**DELEGATED DECISION TO DETERMINE APPLICATIONS FOR
NON-MATERIAL AMENDMENTS**

Reference No: 2026/NM/91490/W

Site Address: Land off, Bankfield Drive, Holmbridge, Holmfirth, HD9 2PH

Description: Non material amendment to previous permission 2023/91212 for erection of 21 dwellings with access from Laithe Avenue

Planning condition 23 – Materials Rev A

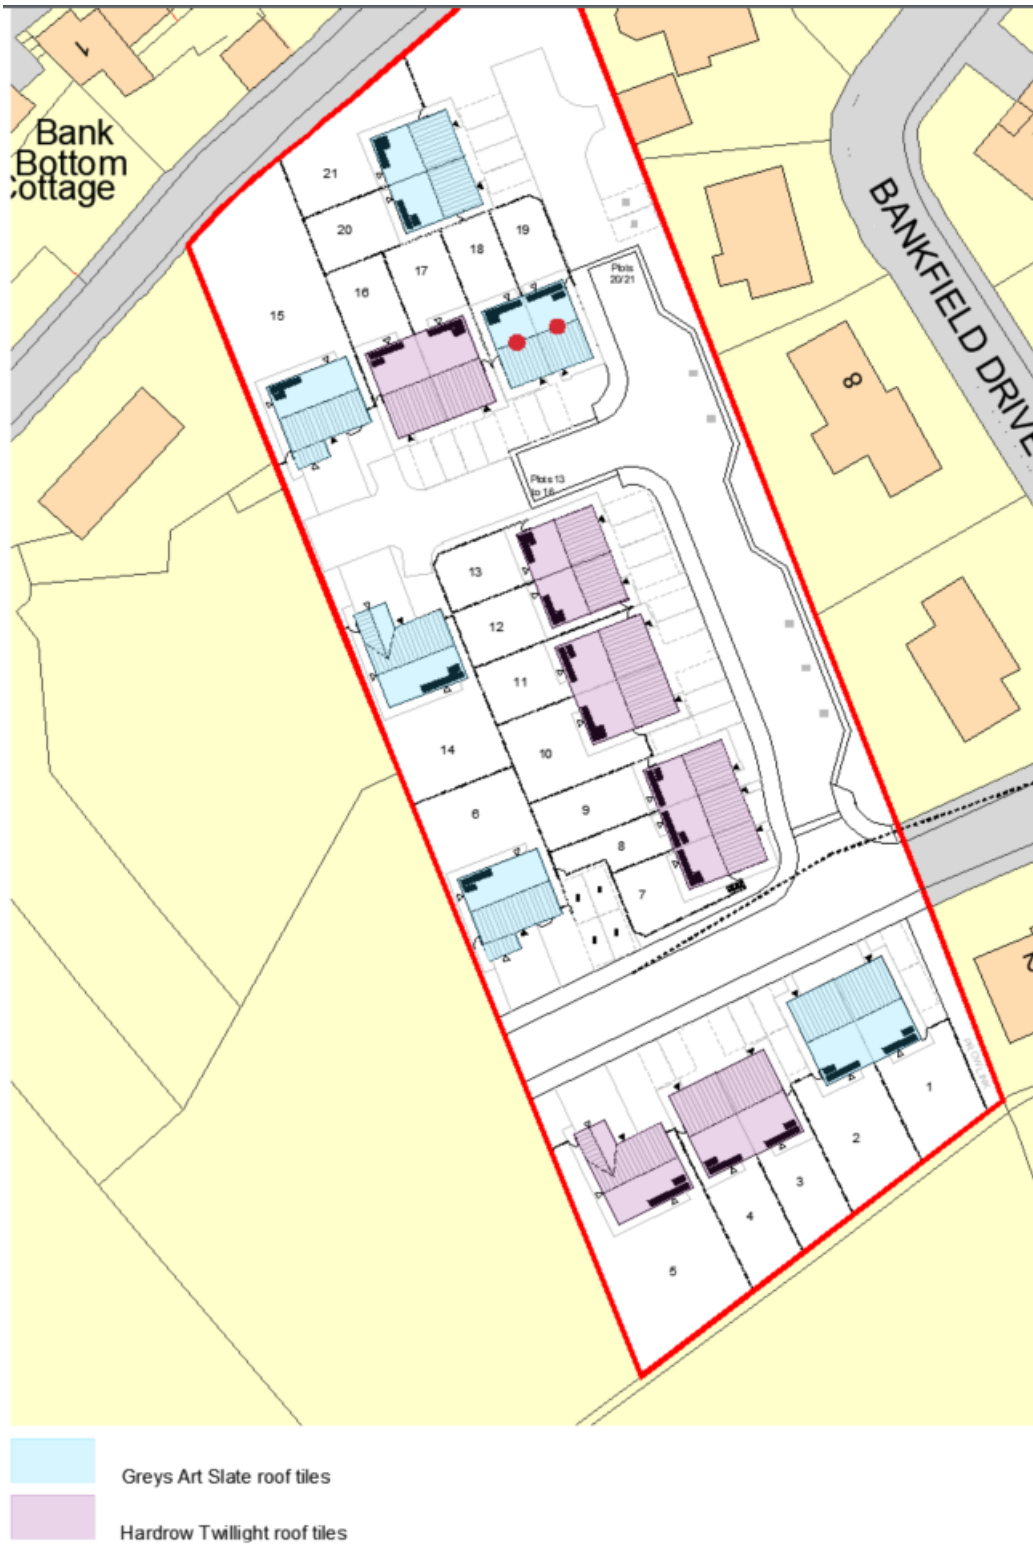
The application proposes a secondary roofing material, due to the manufacture of the approved tiles (Hardrow Twillight roof tiles) no longer being able to produce enough supply for the full development. As such, an alternative material has been proposed which is Grays Art Slate roof tile in the Reproduction Country Weathered reclaimed slate.

The information submitted with this application sets out which units would be constructed from the original, approved roof tile and those that would be constructed from the new proposed roof tile. This includes plots 1, 6, 14, 15, 18, 19, 20 and 21.

Having reviewed the sample provided against the approved walling and roofing materials, along with the applicant also providing an example of where this roofing material has been used locally, officers are satisfied that it would have an acceptable visual finish, that would blend in appropriately within the site and the wider area.
